Planning Application Ref: P/90/19/T

Location: 17 Boleyn Drive, Pagham, PO21 3LG

Description of works: Reduce crowns of 2no. Lombardy poplars by 4-5m & crown thin by 20% on main stems

PLAN TO SHOW POSITION OF
2 LOMBARDY POPLAR TREES IN
REAR GARDEN OF 17 BOLEYN DRIVE
PAGHAM, WEST SUSSEX.

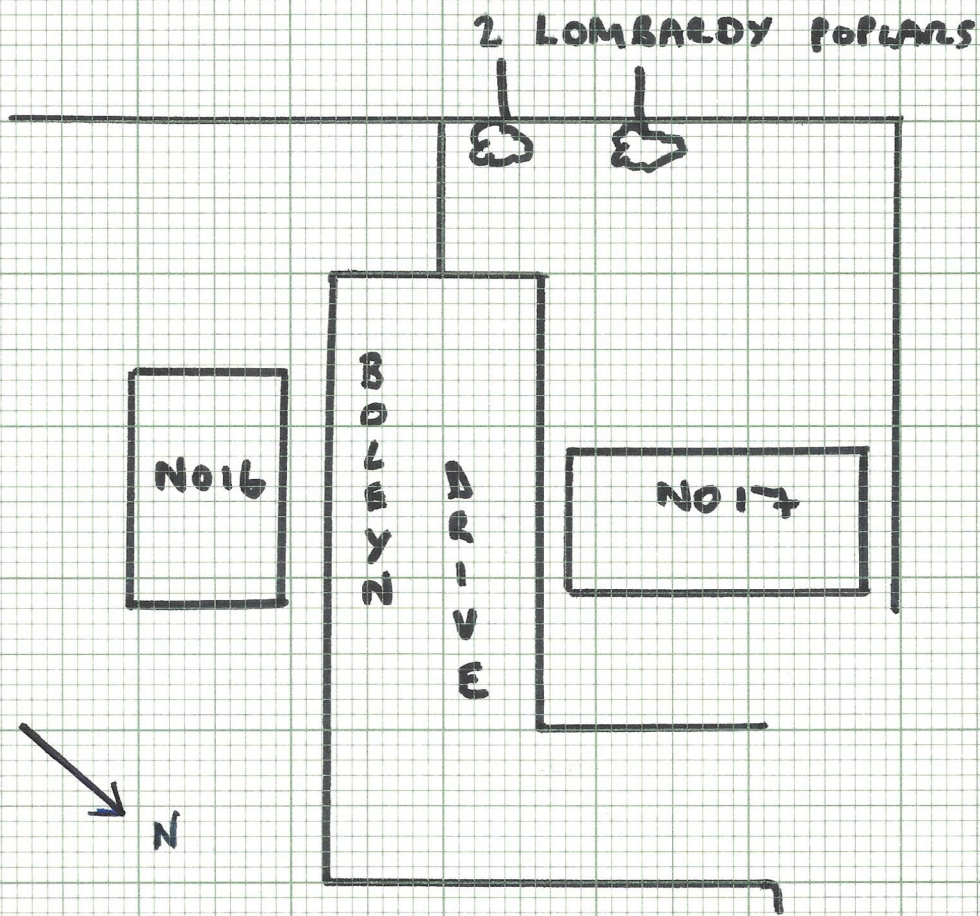
2x Lombardy poplar / *Populus nigra Italica* Approx. height: 12m Average spread: 1.5m Age class: Mature

- Outwardly and from a distance both trees appear (restricted view from road) generally stable and in fair physiological condition at this time.
- They grow at the rear of the property, part of a linear group of the same type spanning several properties. They are visible from surrounding properties and can also be seen in part from public highway. As such, they have some public amenity value despite being aesthetically diminished by severe truncation of their main stems at approx. 8m height.
- Repeat operations such as now being asked for by the applicant will be necessary throughout the remaining life-span of these trees, to achieve a reasonable degree of structural integrity appropriate for their location.

- The proposal to reduce their overall height and spread with a view to restricting growth is justified and consistent with previous works approved by the Local Planning Authority.
- While a temporary loss of aesthetic value is inevitable, satisfactory canopy renewal and recovery should occur if the work is undertaken to a high standard and at an appropriate time of year.

- I recommend **CONSENT** for this application, subject to the following condition:

- Part a) Where whole branches are to be removed and final cuts made close to the trunk or branch union they are to be made as shown in Figure 2 of BS3998:2010
- Part b) Where branches are to be shortened back the final cuts are to be made at the correct angle shown in BS3998:2010 and adjacent to a live bud or lateral.
- Part c) The removal of crown material which has developed since the last operation must be done sympathetically and with respect to established 'knuckles' so as not to extend beyond the point of origin.
- Part d) The long-term vitality of these trees is best respected when significant pruning work such as proposed, is undertaken during the mid-winter (late-December to early-February) period. The work must only be undertaken during this period.
